Planning Inspectorate

Application by The Droves Solar Farm Limited for The Droves Solar Farm

The Examining Authority's written questions and requests for information (ExQ2): Issued on 2 July 2026

DRAWING TITLE
 ES Figure 6.12 Viewpoint 12 - Castle Acre Priory, Castle Acre
 REVISION P1, Text update DRN JB CHK OWh/MB APP RP
 DWG NO 9485_0522 DATE 06/01/2026 Sheet 1 of 2

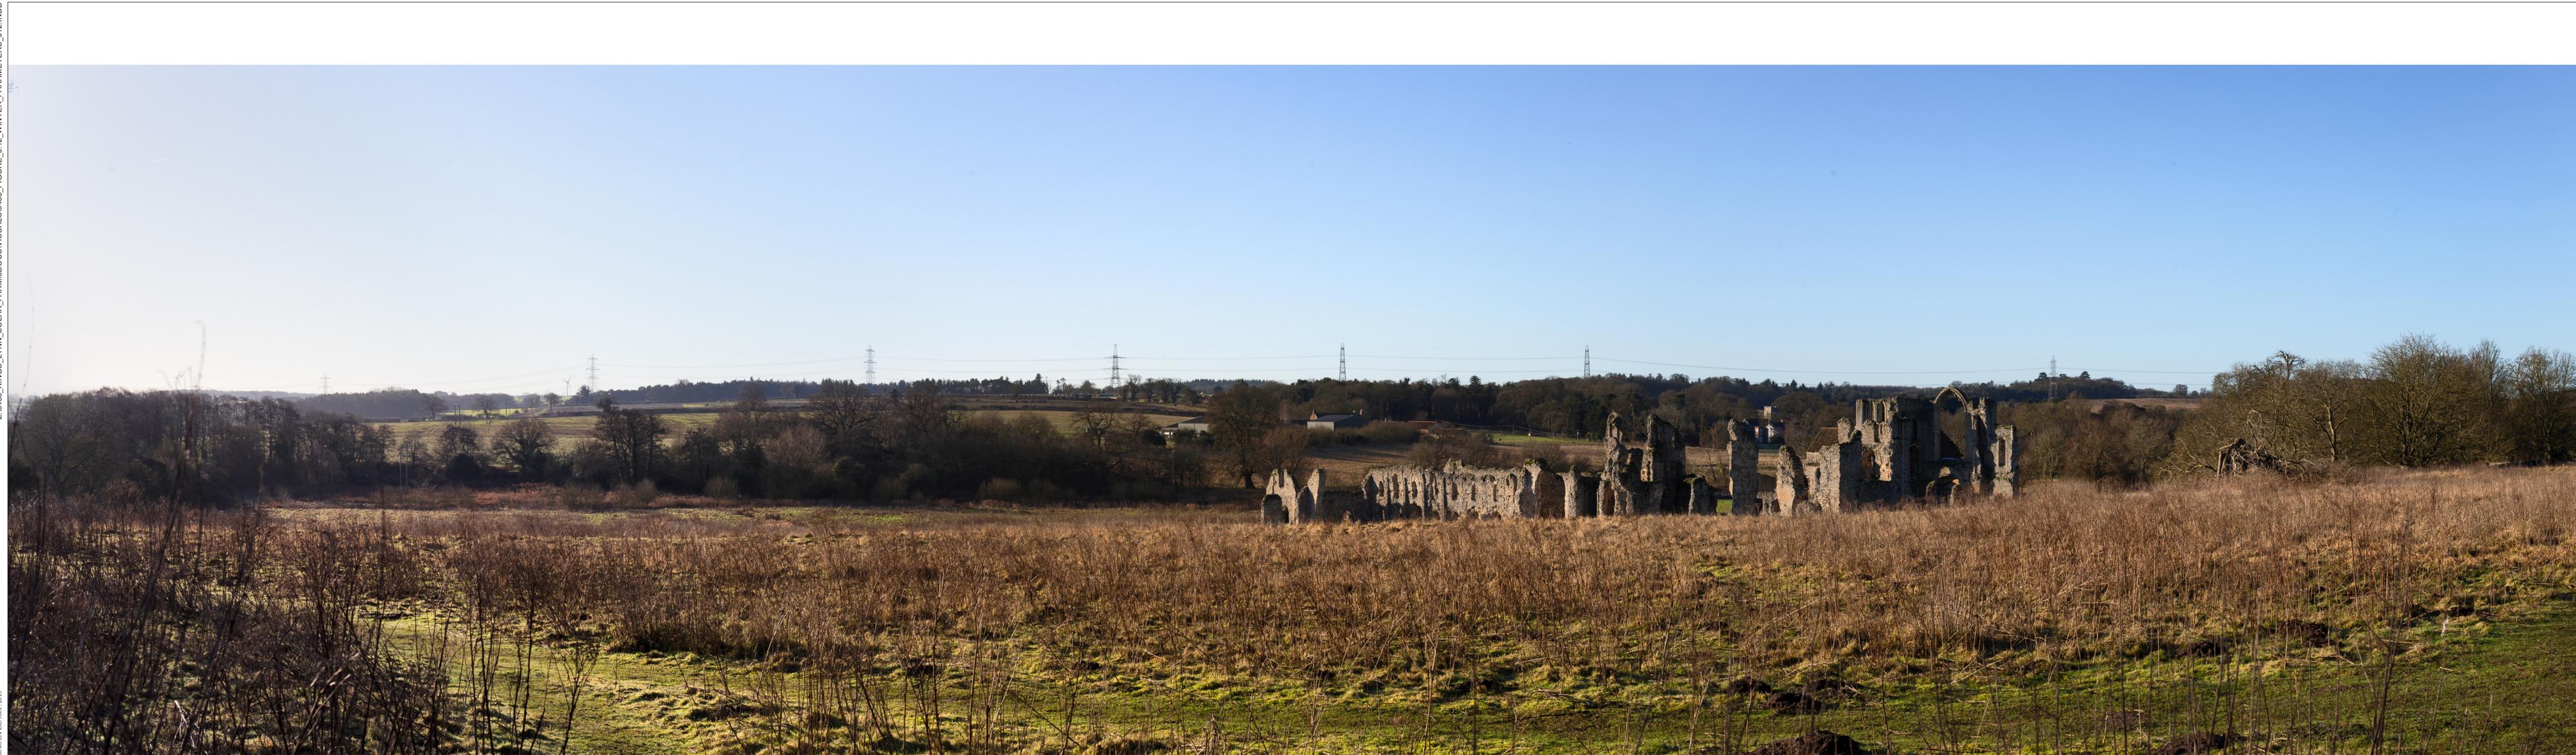
Q9.0.2	The applicant	<p>Scenario A (both existing and new pylons) and Scenario B (double turn in option)</p> <p>Further to the applicant's response to ExQ1 Q9.0.1 part (iv) [REP1-069], the ExA notes that ES Appendix 5.1 Illustrative Technical Information (Tracked) Section 2: Illustrative Grid Connection Infrastructure Routing [REP1-047] provides a plan view showing the proposed double turn in diversion which shows the extent of the overhead line to be removed to the north of Bartholomew's Hill plantation.</p> <p>(i) Could the applicant confirm whether Scenario A (both existing and new pylons) is shown in its photomontages ES Figure 6.14 PM8, PM12 and PM14 Winter Photomontages - Illustrative Scheme Parts A, B and C [APP-103] [APP-104] [APP-105].</p> <p>(ii) Could the applicant confirm whether Scenario A (both existing and new pylons) is shown in its wirelines ES Figure 6.12 PM6, PM8, PM12 and PM14 Parameter Based Winter Photowires Parts A, B, C and D [APP-095] [APP-096] [APP-097] [APP-098].</p>
